Reference: Office Change of Use at 216 Connie Ct. Spring Lake-Ramp Footing

This correspondence is being issued in response to the as built footing condition at the ramp.

7 RAMP BASE DETAIL
1/2" = 1'-0"

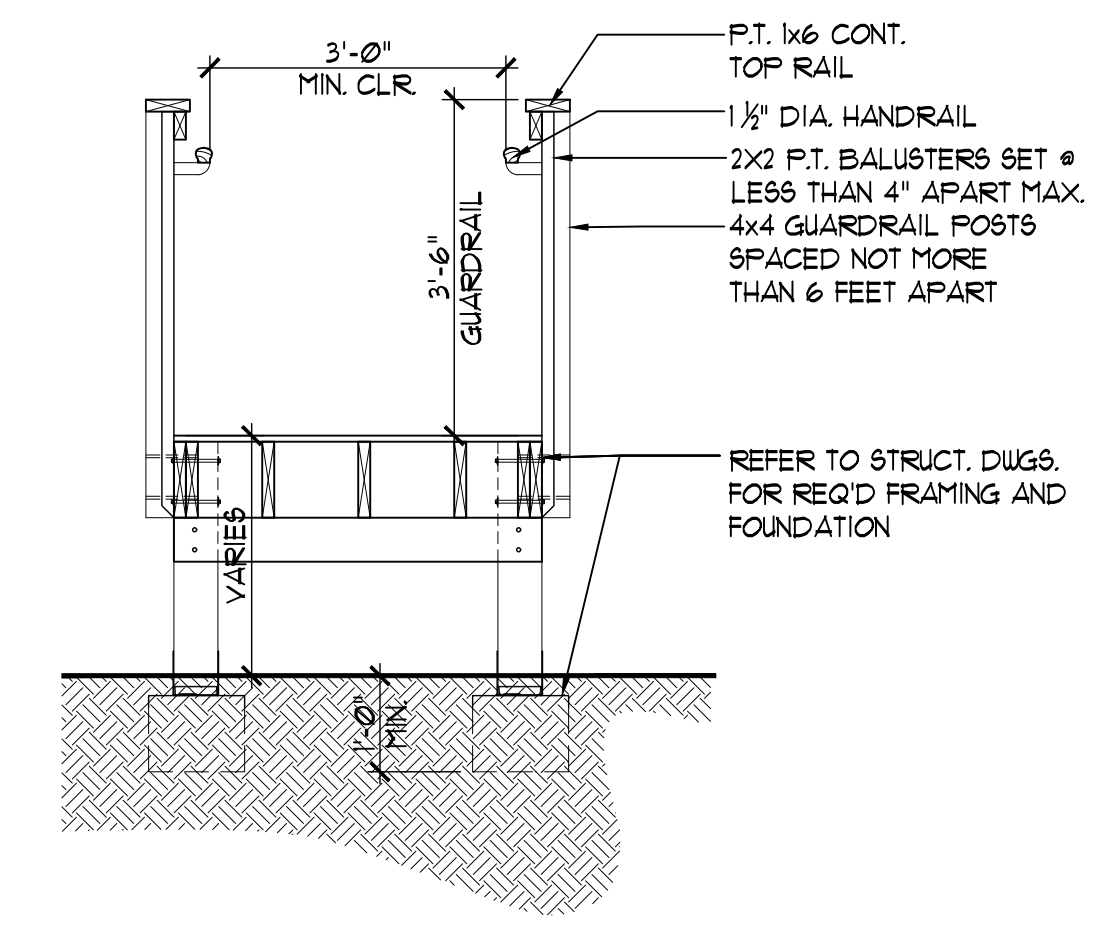
The structural drawings call for 12"x12" footings, min. 12" depth, poured 8" deep at the ramp posts and 12" at the bottom where the ramp ends.

Per the as-built pictures, 12" round footings have been installed. This is sufficient for the required length and width. Our office could not verify if the footings have been poured 12". If they have been poured to a depth 12" below grade, they are sufficient as installed.
